Representation made to Open Forum meeting on 24th April, 2019 concerning Vattenfall

My name is Simon Fowler and I chair Little Dunham Parish Council. We have some experience of large infrastructure applications such as this, having opposed Warwick Energy for some two and a half years and through two planning appeals in connection with their original application to have the current substation located immediately adjacent to Little Dunham on some of the highest land in Norfolk. That application was eventually withdrawn. The reason I mention this is that the first appeal by Warwick Energy against the local planning authority's refusal failed on landscaping grounds. Warwick Energy were then allowed to alter their application so that the substation would be for alternating current only and this removed the requirement for the large convertor buildings shown in this application. Madam, if you were to decide that no amount of landscape mitigation is going to be adequate then I would suggest that you could follow this example.

Indicative Onshore Project Substation
Mitigation Planting - Norfolk Vanguard

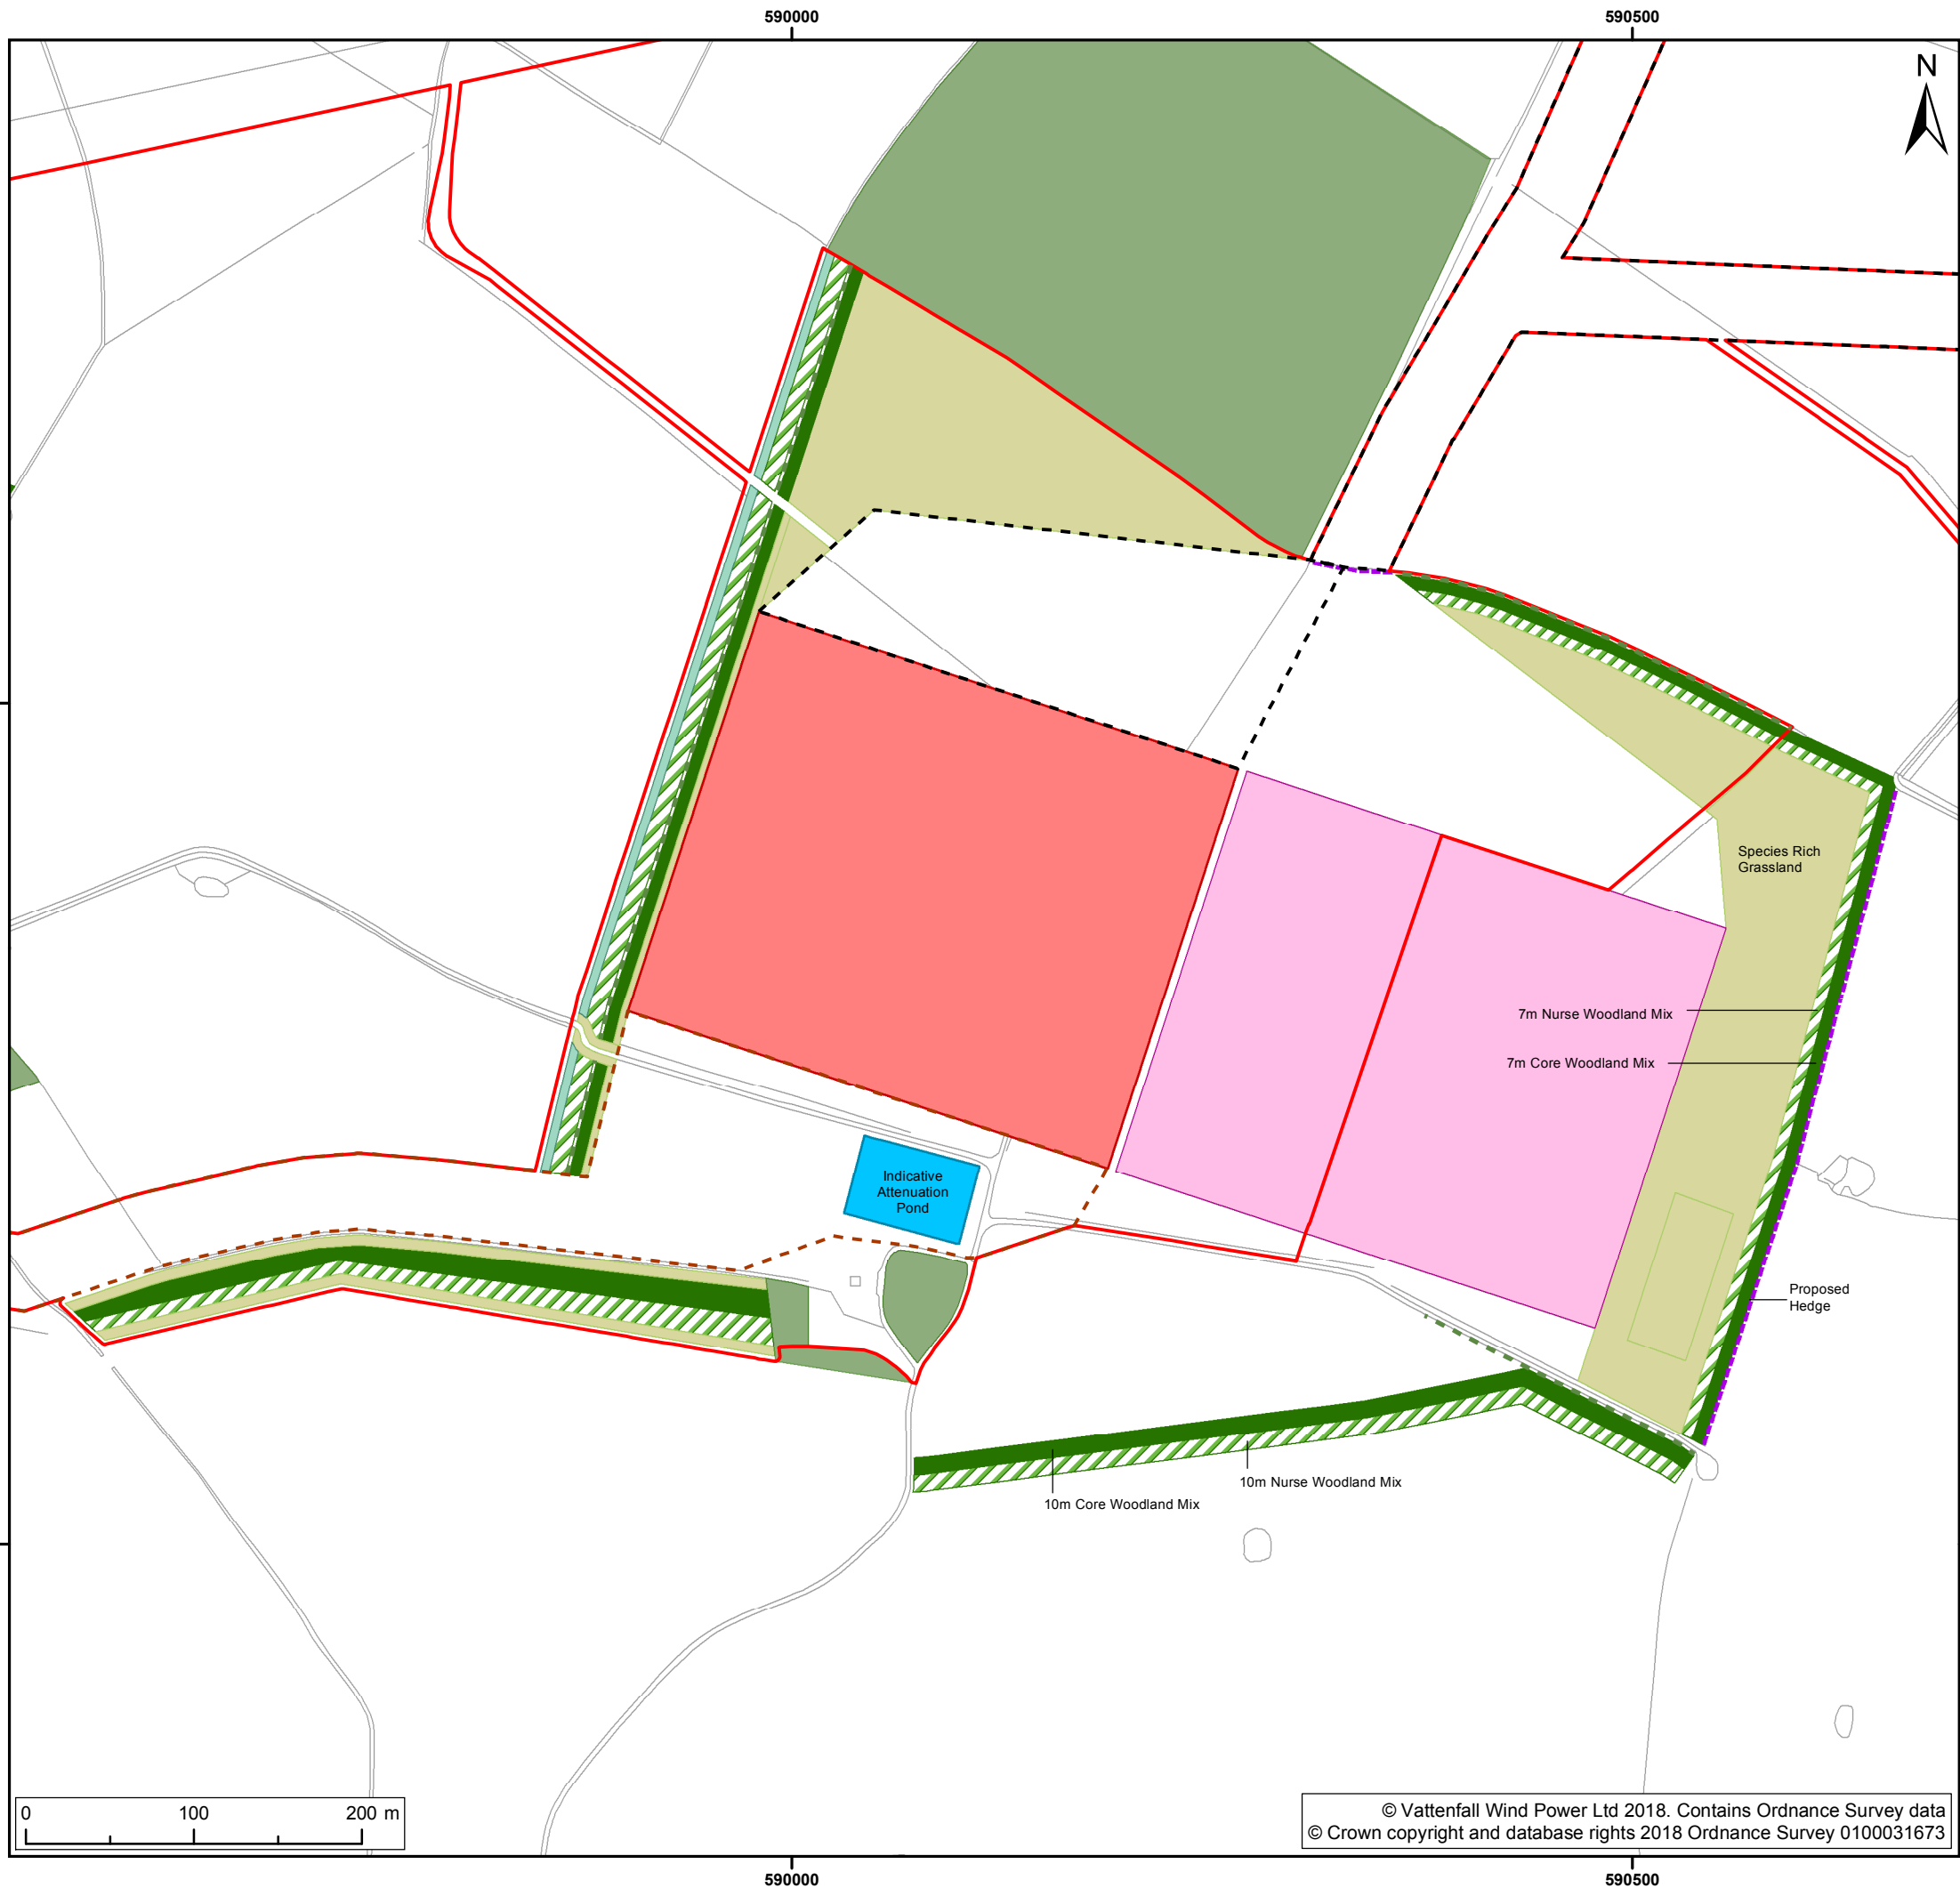
Madam, I have been requested by Little Dunham Parish Council to address you only on the question of landscape mitigation. You will appreciate that the applicant's landscaping proposals are not detailed and I would submit that the information supplied shows them to be inadequate. I am aware of the directions issued to applicants as the result of the Rochdale cases. However I would suggest that this should not be used as an excuse by applicants to fail to provide anything other than rudimentary indications of what we consider to be wholly insubstantial landscape mitigation measures. I would like to refer to Mr Justice Sullivan's judgement when he referred to the abuse of the need for flexibility "this does not give developers an excuse to provide inadequate descriptions of their projects. It will be for the authority responsible for issuing the development consent to decide whether it is satisfied, given the nature of the project in question, that it has 'full knowledge' of its likely significant effects on the environment. If it considers that an unnecessary degree of flexibility, and hence uncertainty as to the likely environmental effects, has been incorporated into the description of the development, then it can require more detail, or refuse consent" (para.95).

Such information as we have been able to find indicates that two metre high bunds will be built on which trees will be planted. Firstly it is generally accepted that trees in Norfolk are only in leaf for five months of the year and secondly the applicants themselves on page 117 of Chapter 29 of your papers indicate that after twenty years the trees will be between 6.75 m and 9.05 m high and after thirty years they will be between 9.25 m and 12.55 m high. If you take an average of these figures then the applicant is admitting that the trees will come up to only half the nineteen metres height of the substantial convertor buildings. This should be unacceptable.

Madam, our request to you is that you require the applicant to provide detailed plans and proposals at this stage for effective landscaping particularly from the viewpoints along the A47, ie. viewpoints 5 and 6 before you grant the Development Order and we would like an opportunity to consider such proposals. The applicant concedes on page 121 of Chapter 29 paragraph 163 table 29.15 that there is the potential for significant cumulative effect from the views from the A47 and surely this should be minimised.

Madam, you will also be familiar with Appendix A to the National Grid Guidelines for the siting of substations. These require applicants to set out mitigation measures where significant adverse effects are identified and refer specifically to design, colour, landscaping and tree planting. Madam, we are fortunate to have on our Parish Council a man with both practical experience and academic qualifications in landscaping and we would be prepared to help with and comment on the measures referred to in Appendix A but we are unable to assist without more detailed plans and proposals being available.

Madam, it is within your powers I think to request that the applicant provides more specific details of landscape mitigation at this stage and I would hope that you press for this and allow time for further discussion.
